Application number: 2024/93043	
What is the application for?:	Certificate of lawfulness for proposed erection of single storey side extensions
Address of the site or building:	85, Hartshead Lane, Hartshead, Liversedge, WF15 8AL
Postcode:	WF15 8AL

User comments

Drawing Status:	PLANNING
Client:	Huda Jawad
Project:	85 Harthhead Ln, Harthhead, Liversedge, WF15 8AL
Drawing:	PROPOSED PLANS.
Project No:	1790
Drawing No:	02_00
Scale: (A1)	1:100
Date:	Jul '24
Checked by:	FN

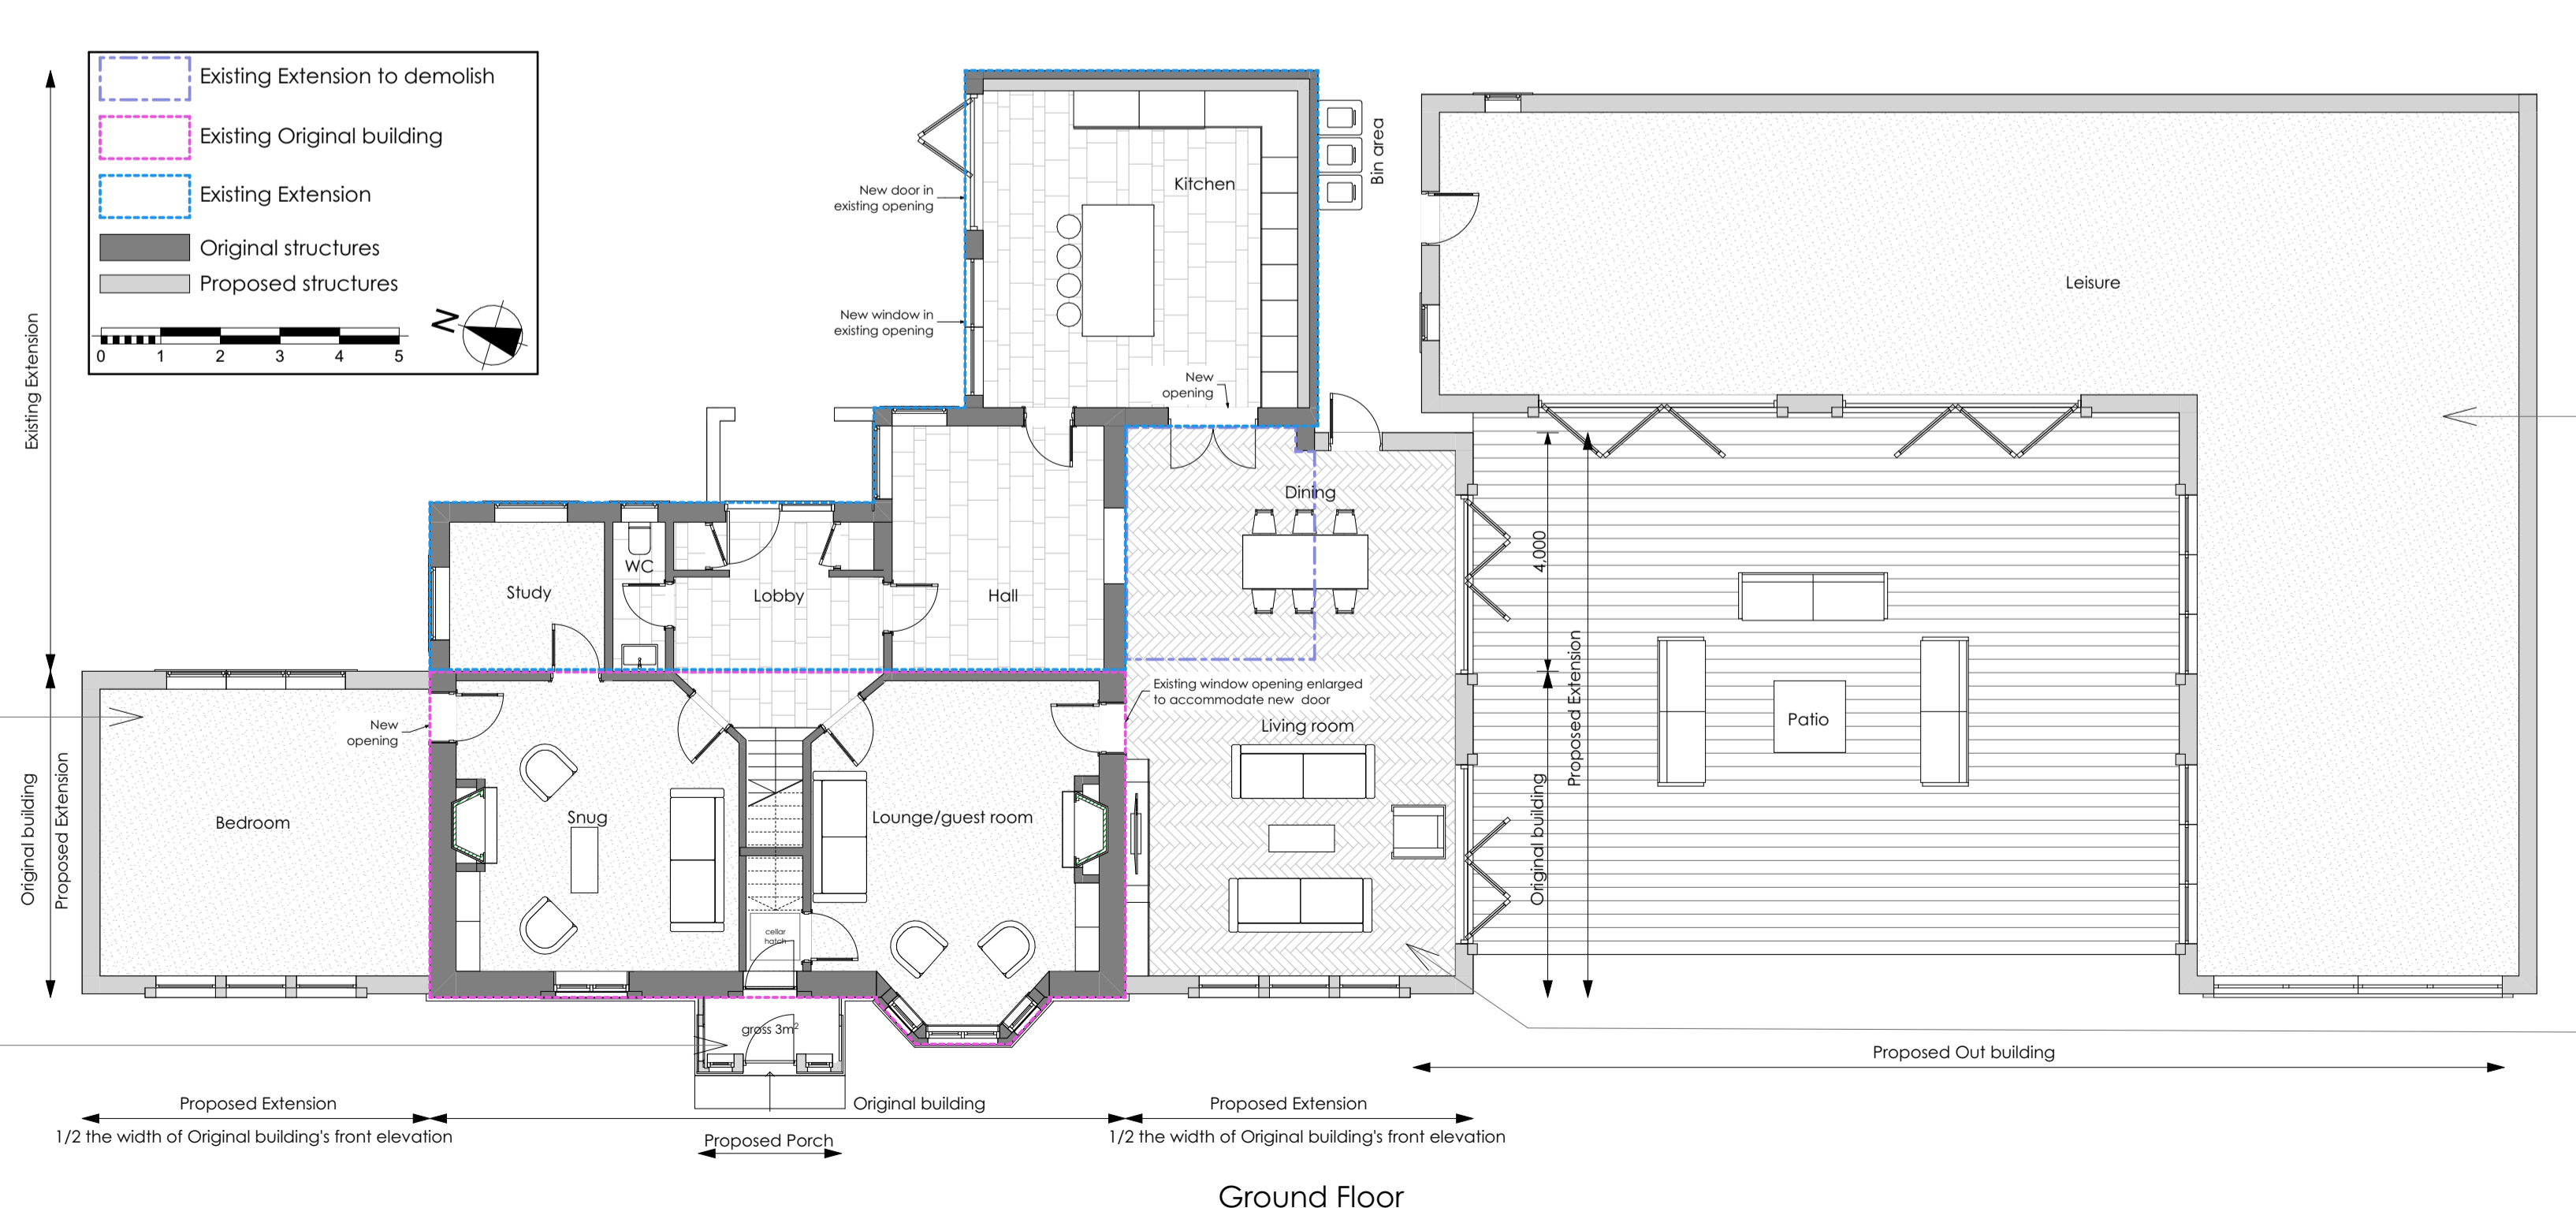
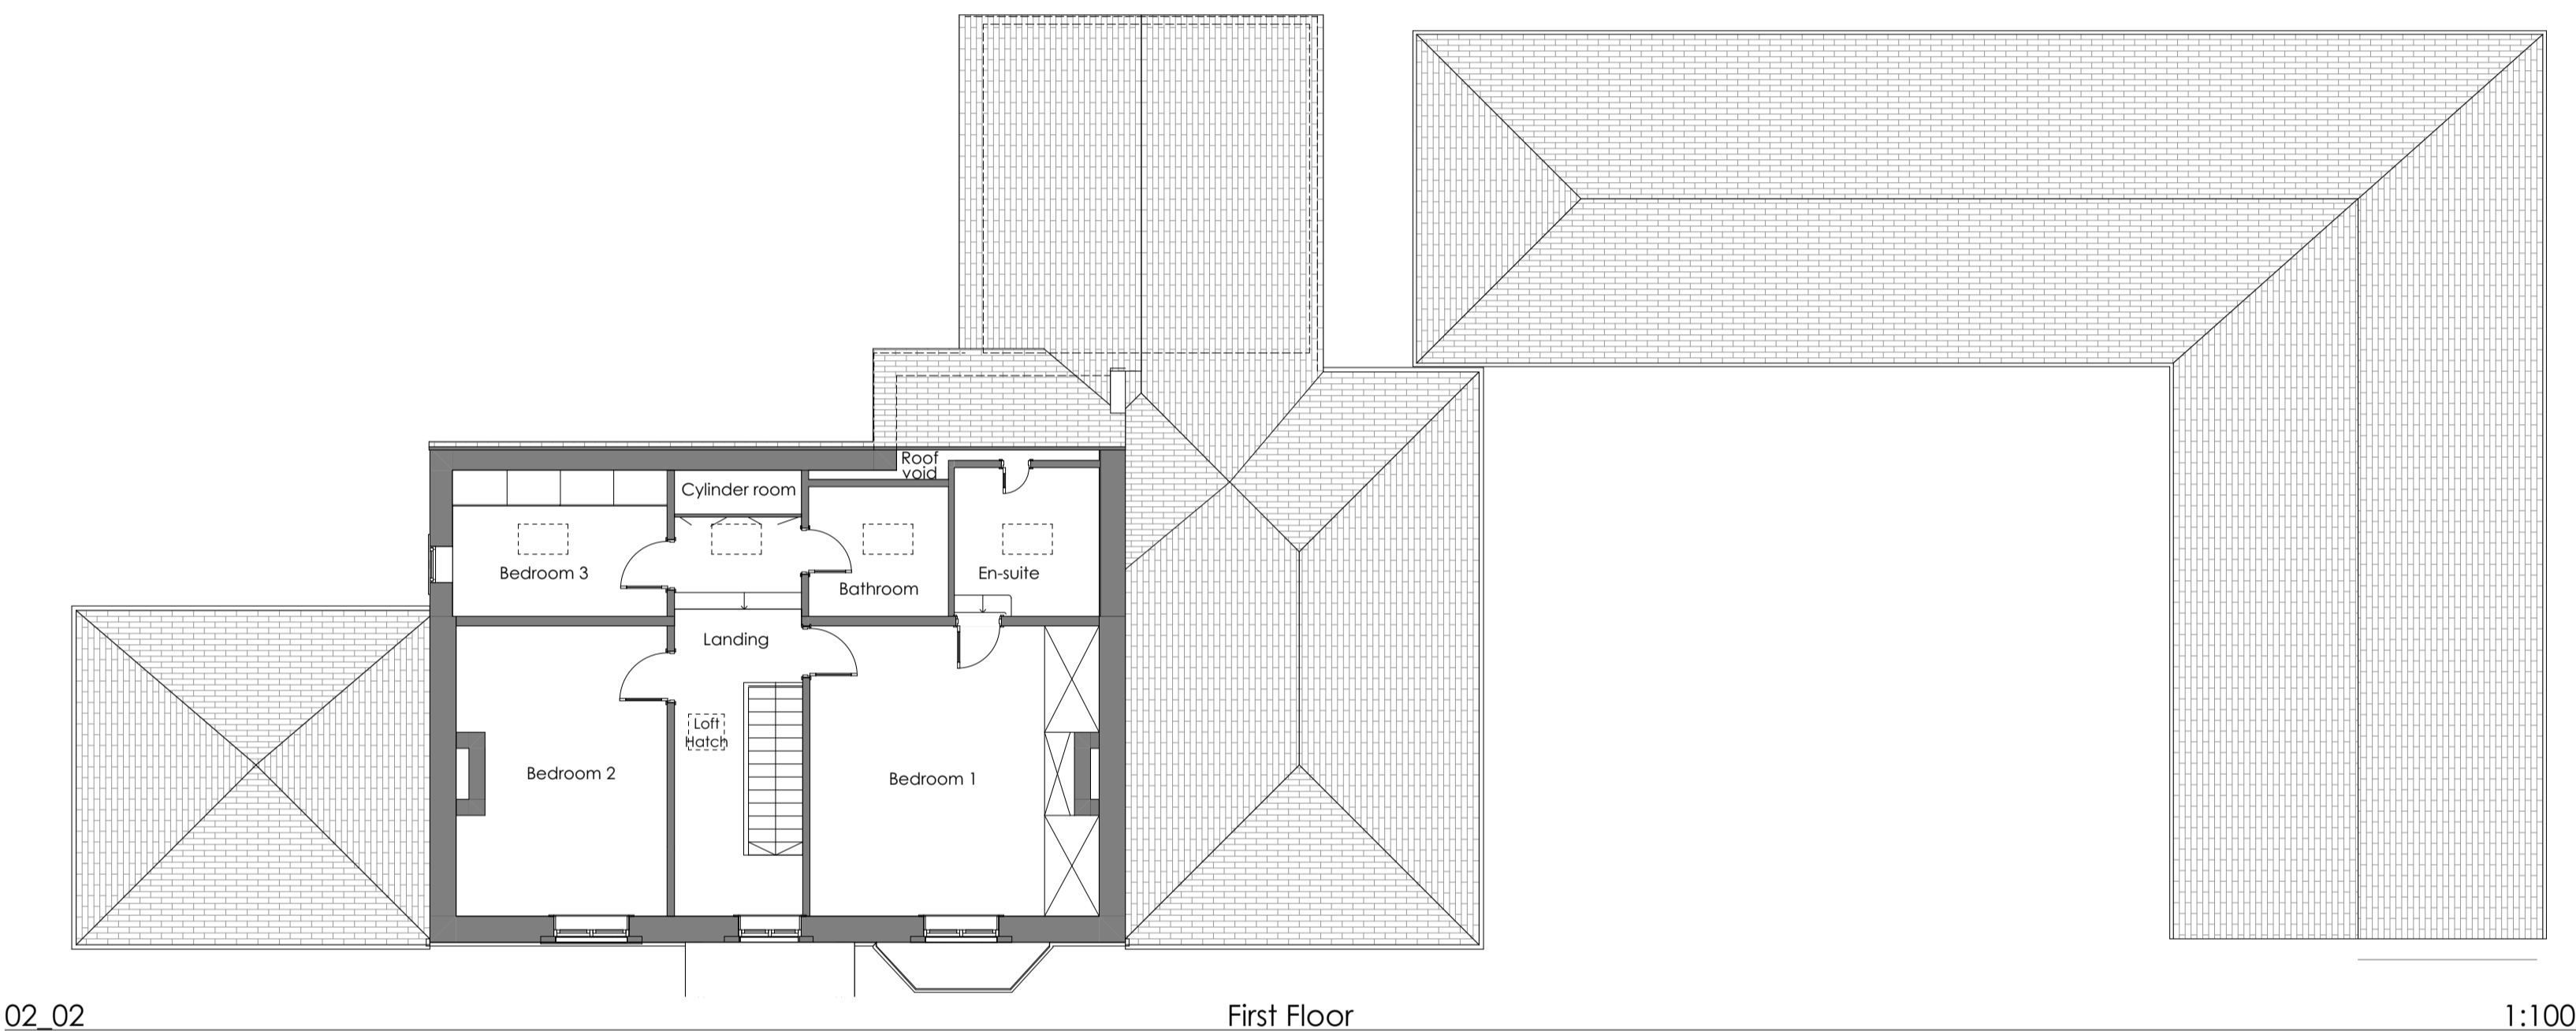
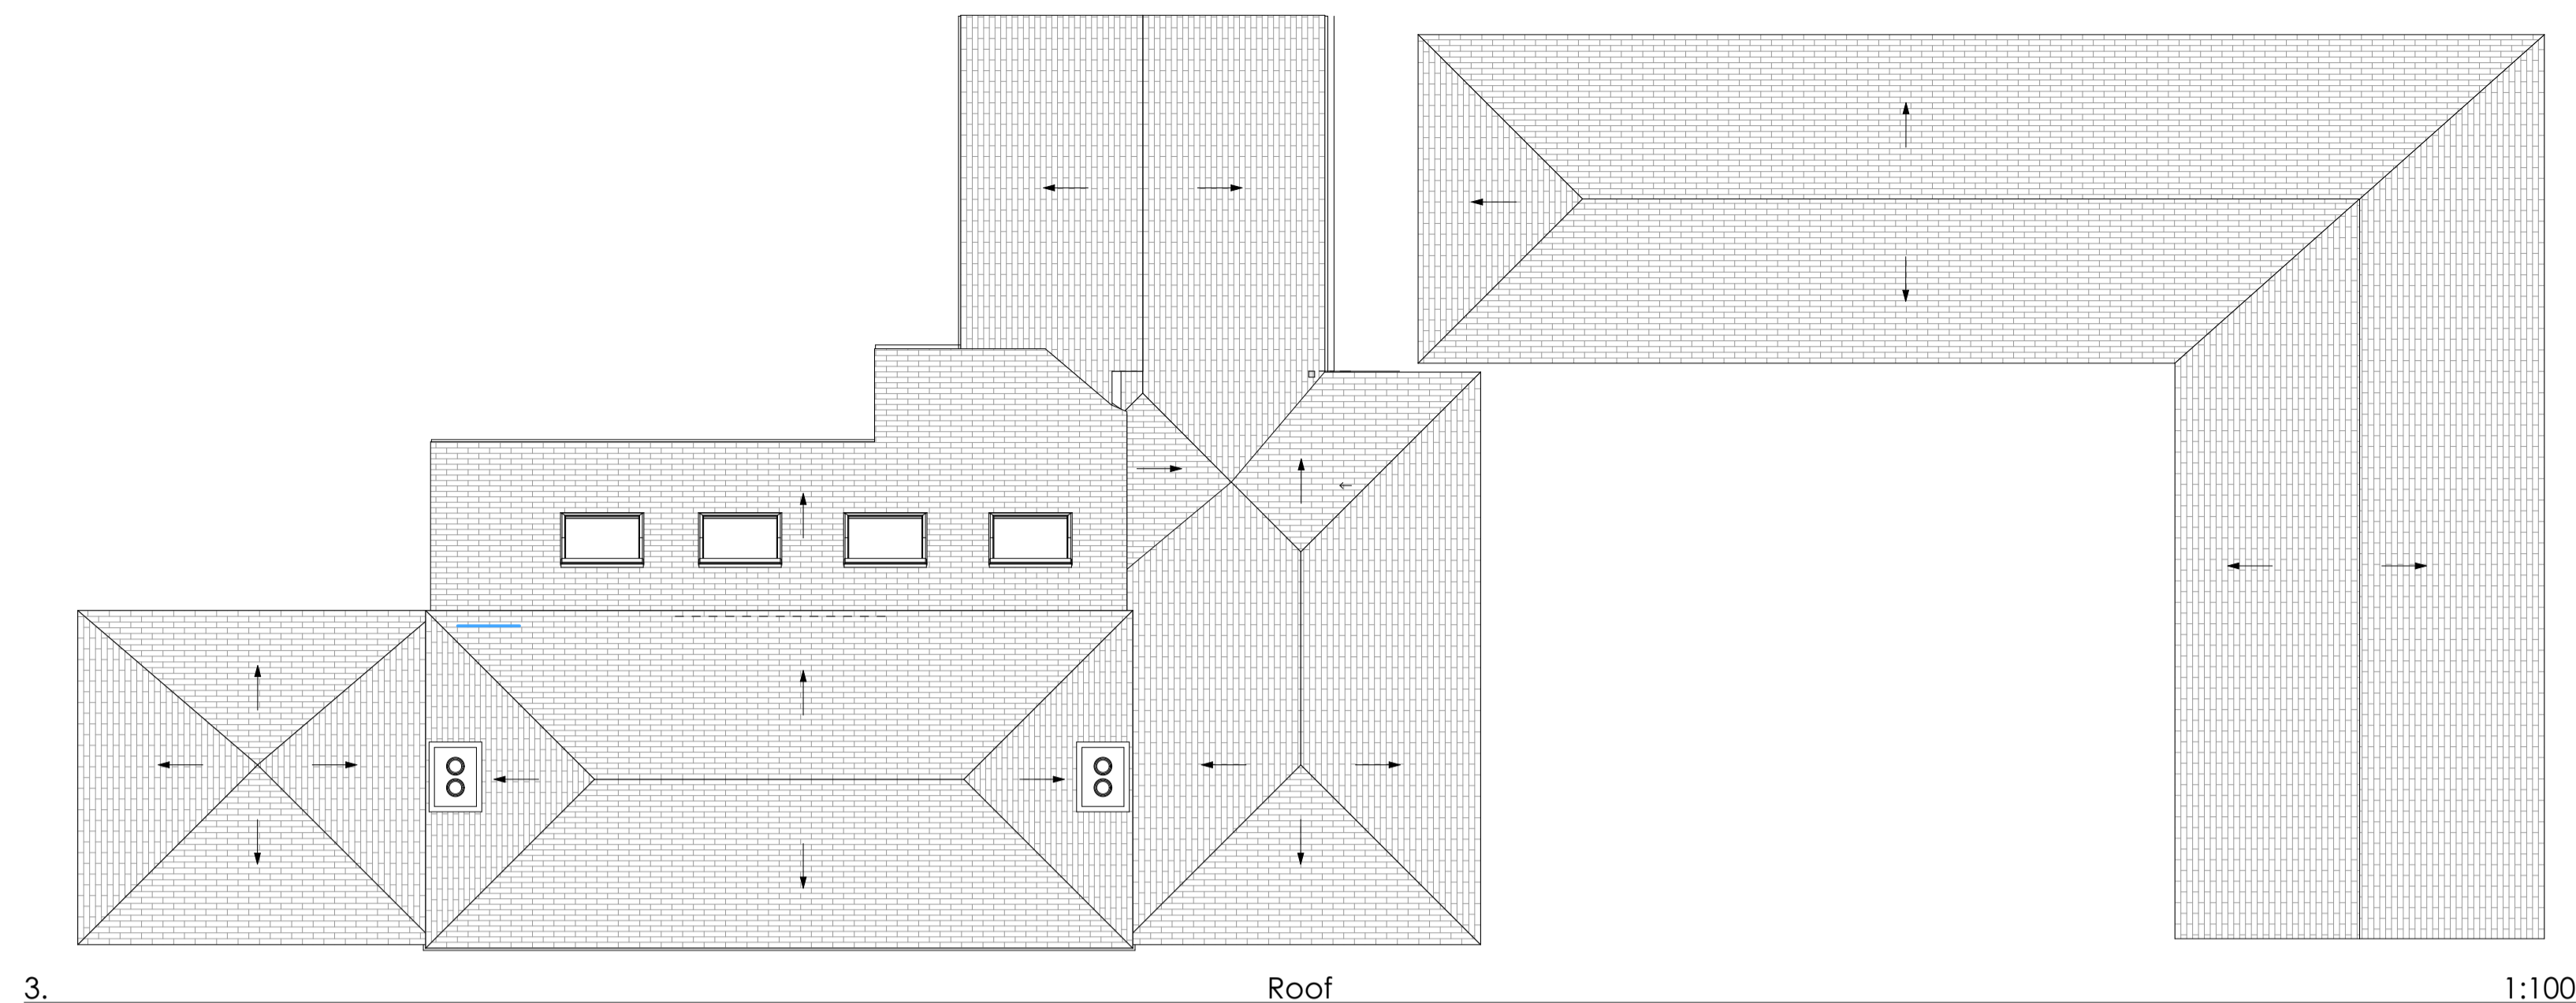
Given that the application is for a Certificate of Lawfulness we would like to focus our objections on the legal issues surrounding the very large outbuilding on the right hand side of the property.

- The building appears to be substantially larger than the 154m² shown in the plans and is likely to be nearer 200m².
- The outbuilding is a quasi extension as it is only around 0.4m from the main house at the narrowest part and actually overlaps with the main building. It has clearly been designed to look the same as the main building and cannot be considered to be distinct and separate from the main house.
- It does not appear to have a clear purpose or function other than maximising its size in the available space.
- The style, layout and design is very similar to the main building and for this reason looks like a very large extension.
- This building will cover around three quarters of my garden width to an overall height of 4.1m which seems very out of line with residential development on greenbelt site.

Drawing: **PROPOSED SITE PLAN.**

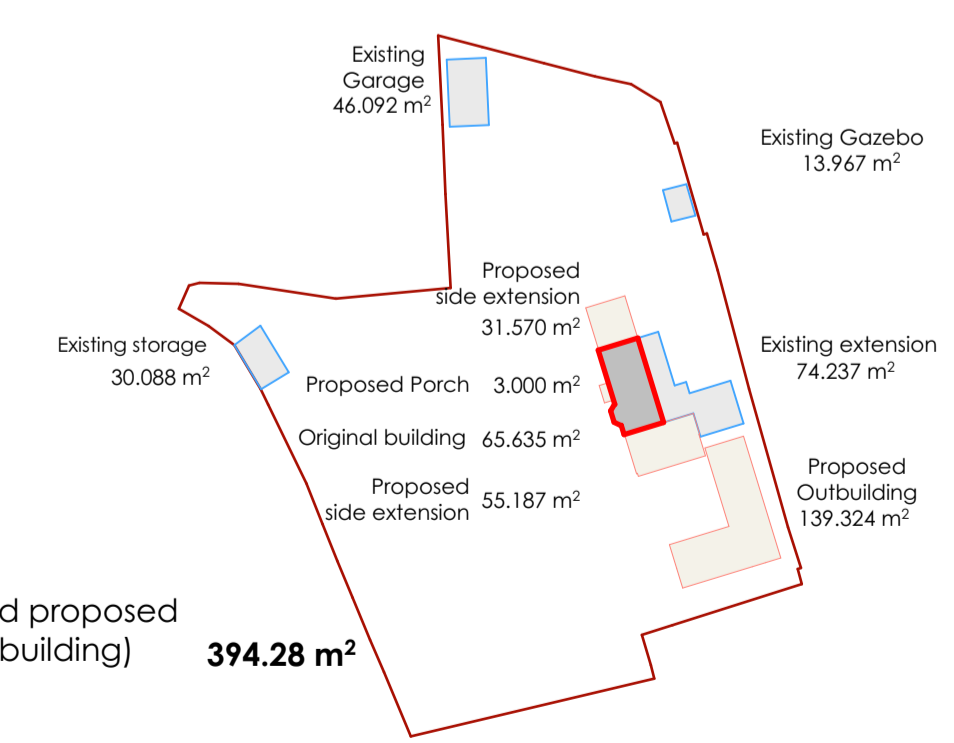
We object to the inappropriate design and huge scale of this development in a greenbelt area. The original building had a footprint of 65m² and the proposed new development is over 409m². We also believe the application is in the form of a Certificate of Lawfulness rather than a full planning application to reduce the level of external scrutiny and to get around the constraints of the original limited footprint of the house. Please note there has already been significant development of the site, see new gazebo, patio, and large imposing stone walls to the front and rear of the property.
